**Consultation Response from Mike Hibbert,  
KC Waste Strategy( Refuse & Recycling)**

**2023/90531 Highgate Beds Ltd, Bretton Street, Savile Town, Dewsbury, WF12 9DB**

**Demolition of existing warehouse building and erection of mixed use retail warehouse (Use Class B8), showroom (Ea) and office (B2)**

**Date Responded: 12/04/2023.**

Proposed Site Plan

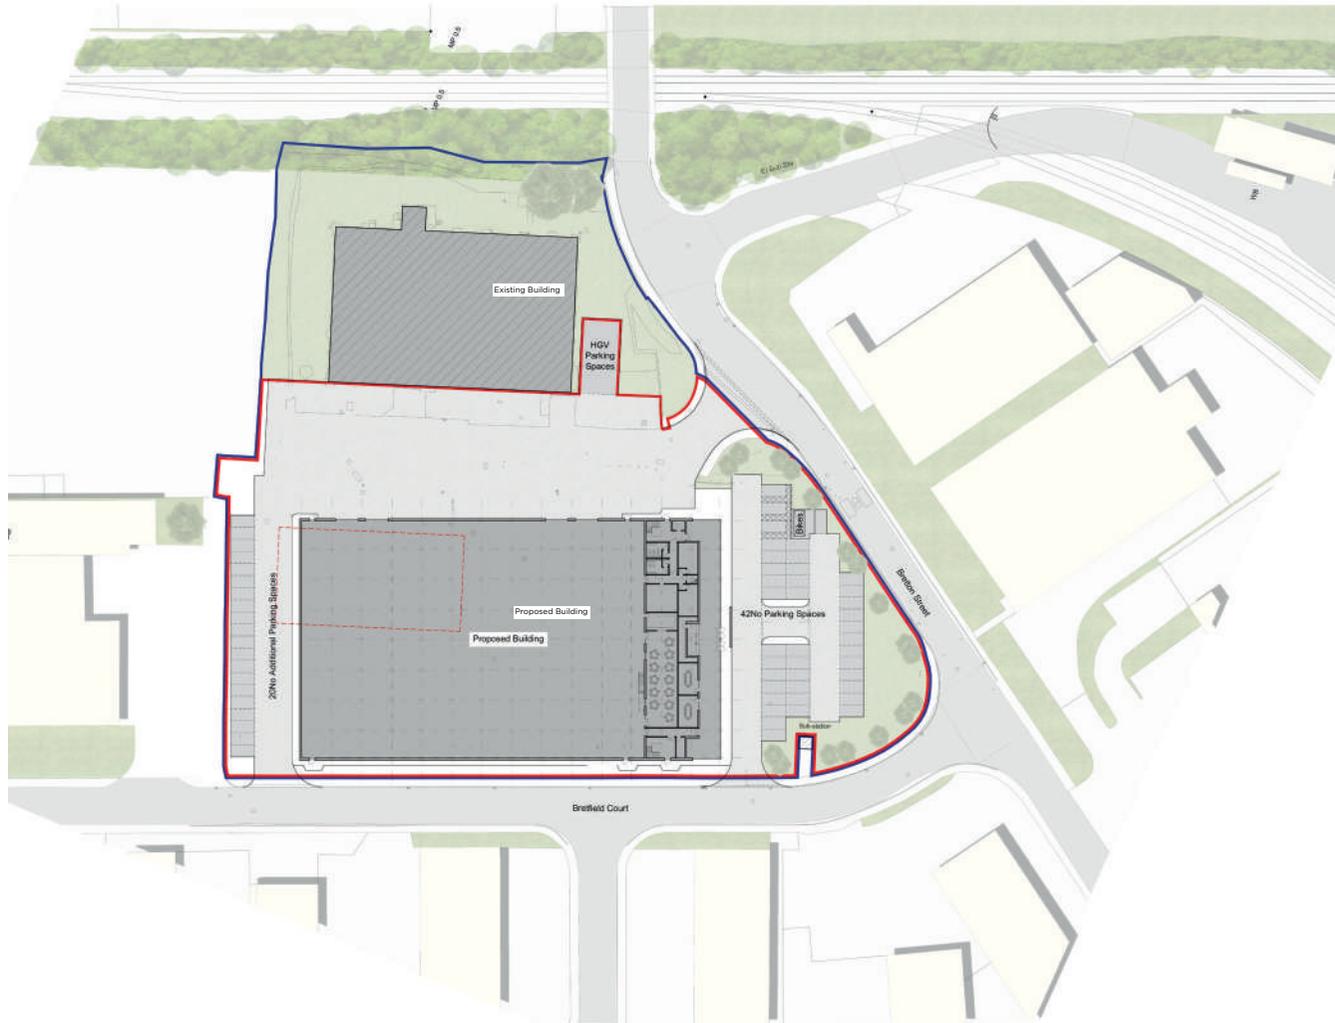
The application form, in the Waste Storage and Collection section, does not include details of waste storage and collection arrangements. Proposed Site Plan Drawing No 003 Rev J dated 7/12/22 is not annotated with information about waste storage locations.

- With limited information included in the application it is therefore difficult to predict likely waste generation and therefore waste storage capacity required. As the applicant has an existing operational facility, waste arisings data should be available and there will be existing provision for waste collection generated from the site. If not using skips, the drag out distance for wheeliebins from a Bin store/ premises to the collection vehicle should preferably be under 15m. Any waste storage area should be secure to prevent theft, unauthorised use/ fly tipping, arson or rough sleeping.
- Waste storage presents a fire risk. Any skip/ wheeliebin storage location should be carefully considered when undertaking a fire risk assessment and may need relocating away from buildings.

- In line with Government's OUR WASTE, OUR RESOURCES: A STRATEGY FOR ENGLAND and the requirement for waste producers to comply with Regulation 12 of The Waste (England and Wales) Regulations 2011 there should be separate provision for recyclates and residual wastes. Waste storage should be identified on site either internally or on the service yard to accommodate general waste and packaging/ cardboard skips. As the facility includes a canteen/ employee rest area then there should be thought to arranging separate collection of food waste and Dry Mixed Recyclables.

- Any waste storage compounds should be large enough to accommodate the waste being stored and constructed with an impermeable floor surface. Specification and guidance can be found in the [Waste Management Design Guide for New Developments \(kirklees.gov.uk\)](https://www.kirklees.gov.uk/beta/planning-policy/adopted-supplementary-planning-documents.aspx)
